April 23, 2013

**Subject: Convenience Store with Fuel Station  
2282 Congress Street  
Fire Department Site Review Checklist-Supplement**

PROJECT: MULTI-USE DEVELOPMENT
2282 CONGRESS ST., PORTLAND, ME
SHEET TITLE: SITE LAYOUT PLAN
CLIENT: CJ DEVELOPERS, INC.
35 PRIMROSE LANE, FREEPORT, MAINE 04032
AND PORTLAND PROPERTY HOLDINGS, LLC
2 MAIN STREET, SUITE 200, TOPSHAM, MAINE 04086

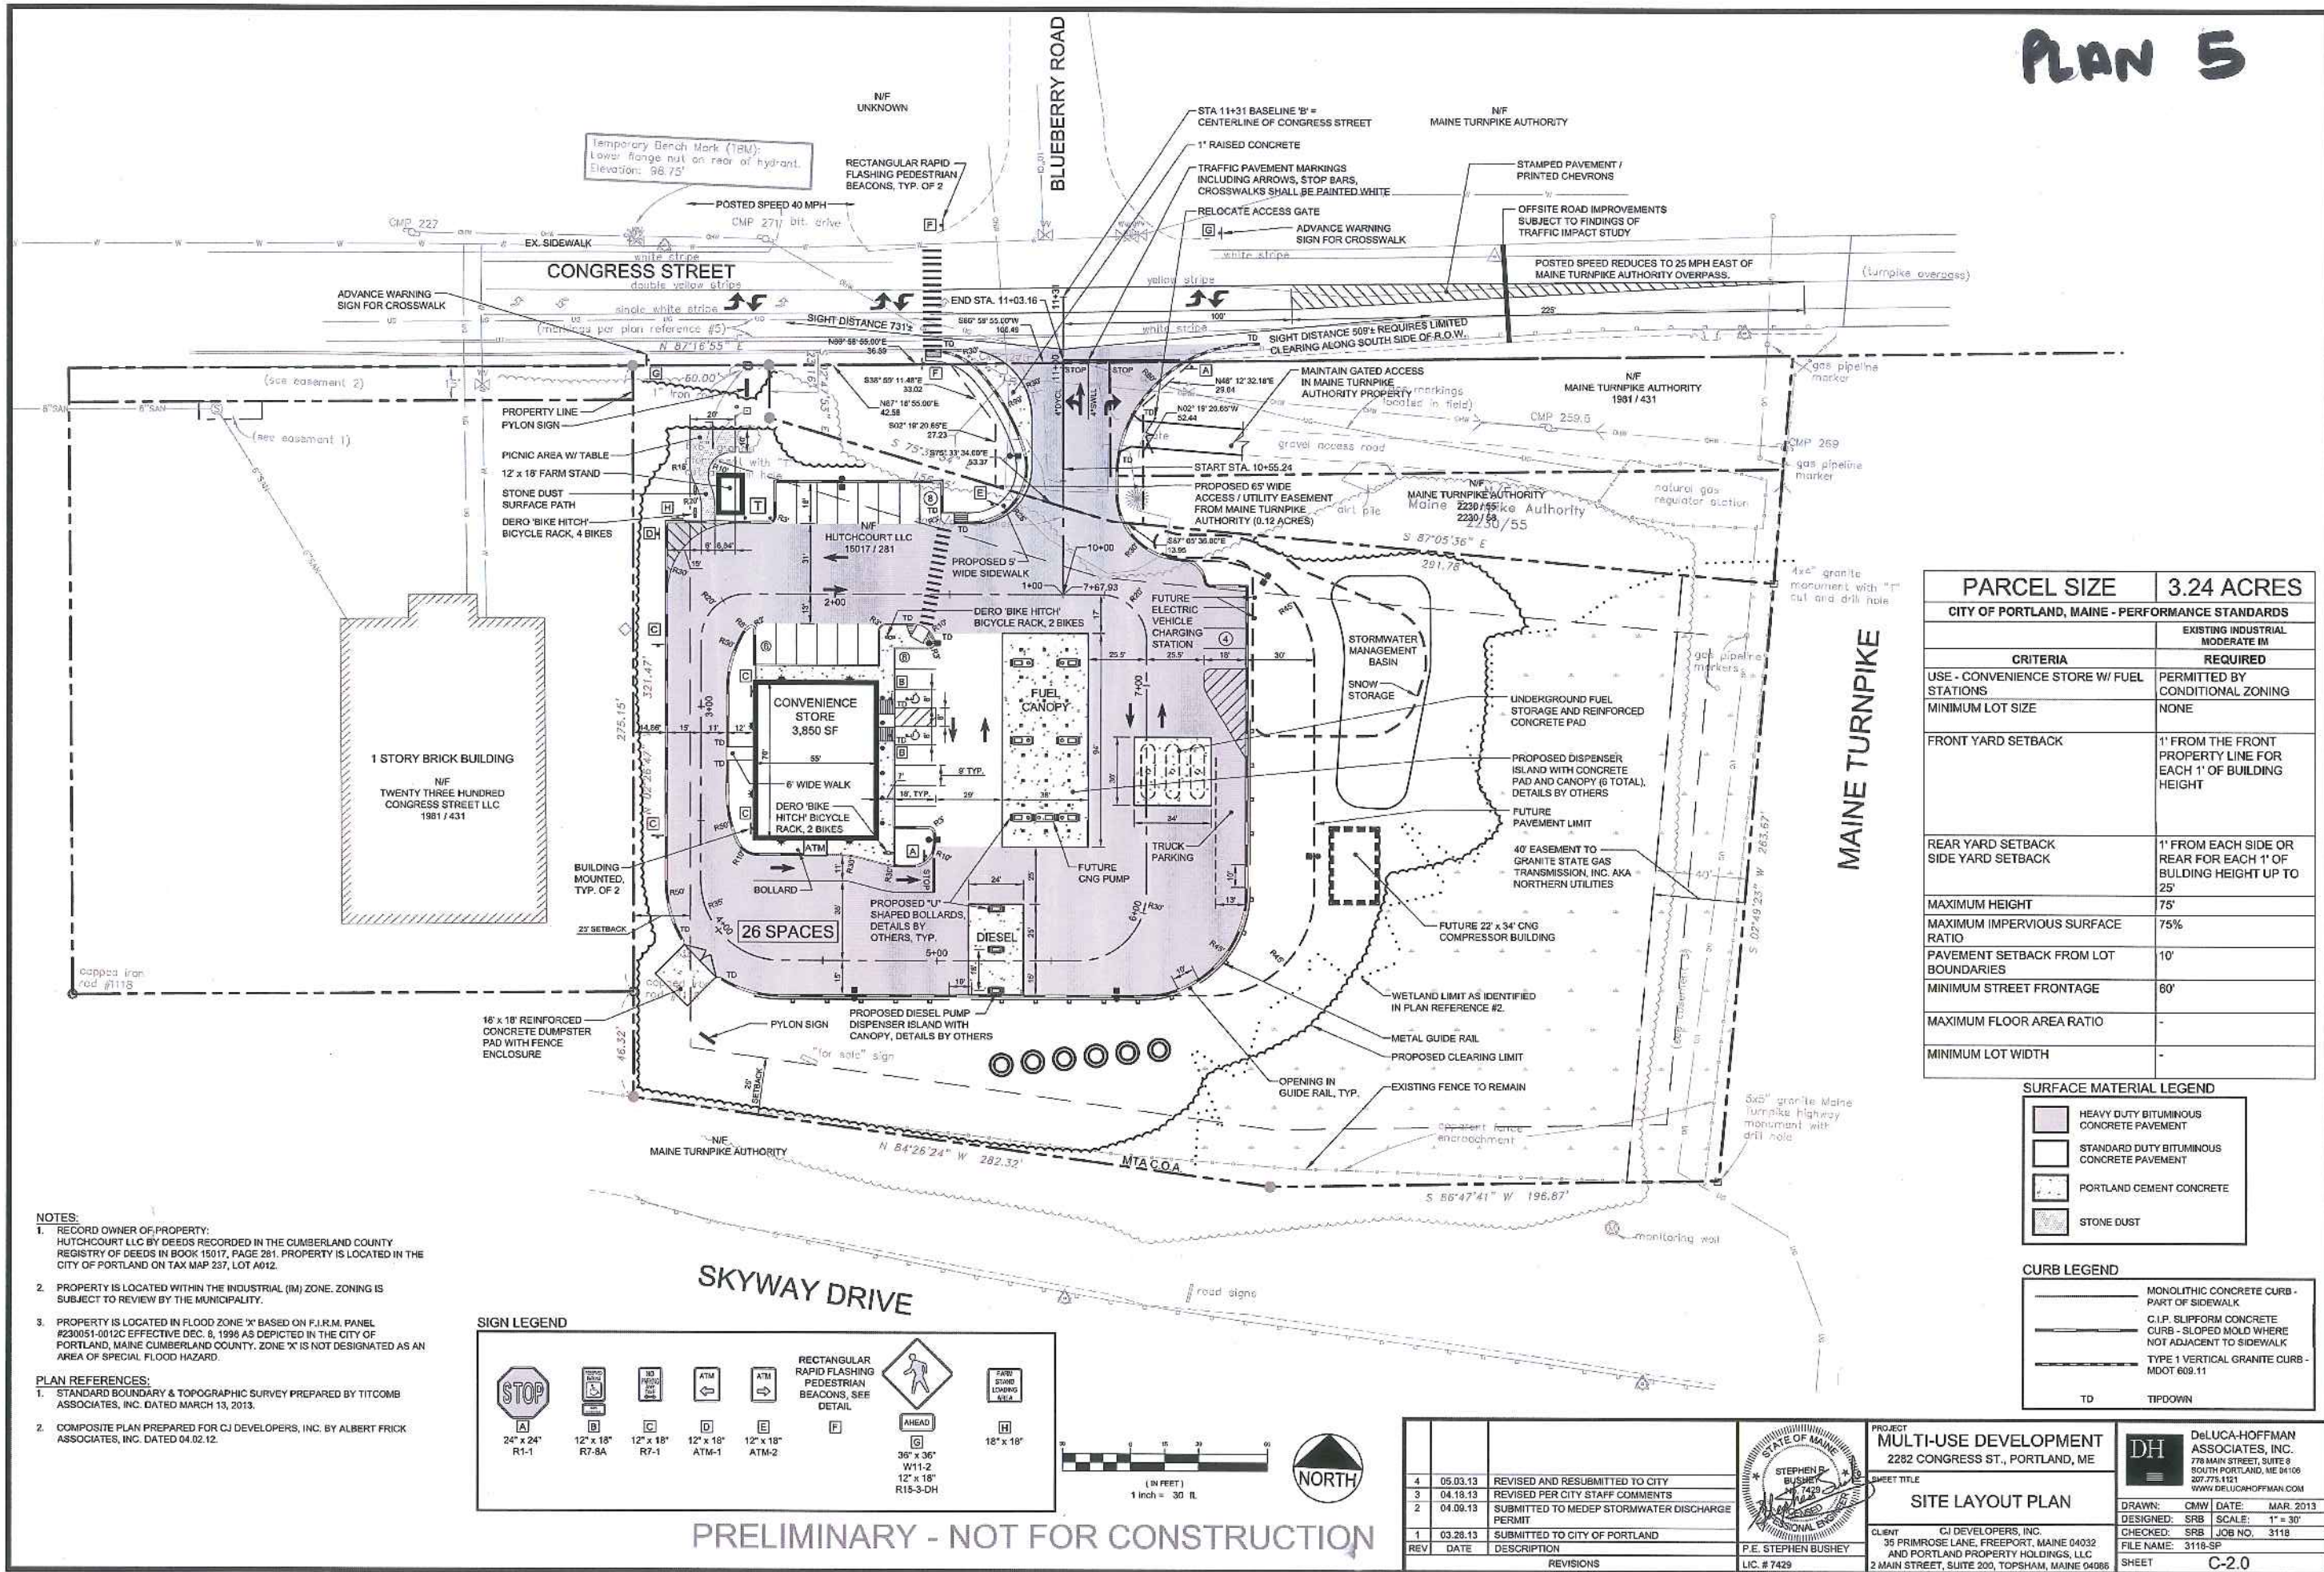
2. *All fire department routes shall be a minimum of 20' wide.*

The site layout plan contains a service route in/out and around the site that is fully capable of allowing full emergency equipment access as evidenced by the accompanying turning movement diagram.

CANOPY ELEVATIONS
A2

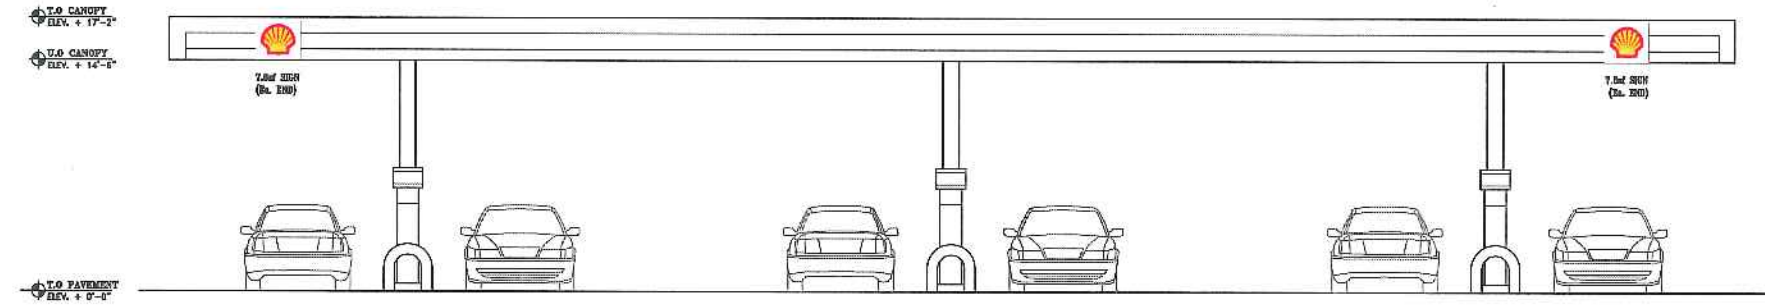
3. *The fuel canopy overhang shall be no less than 13'-1" per NFPA 1 requirements.*

As shown on the accompanying fuel canopy elevation drawing the fuel canopy height will be 14'-6".
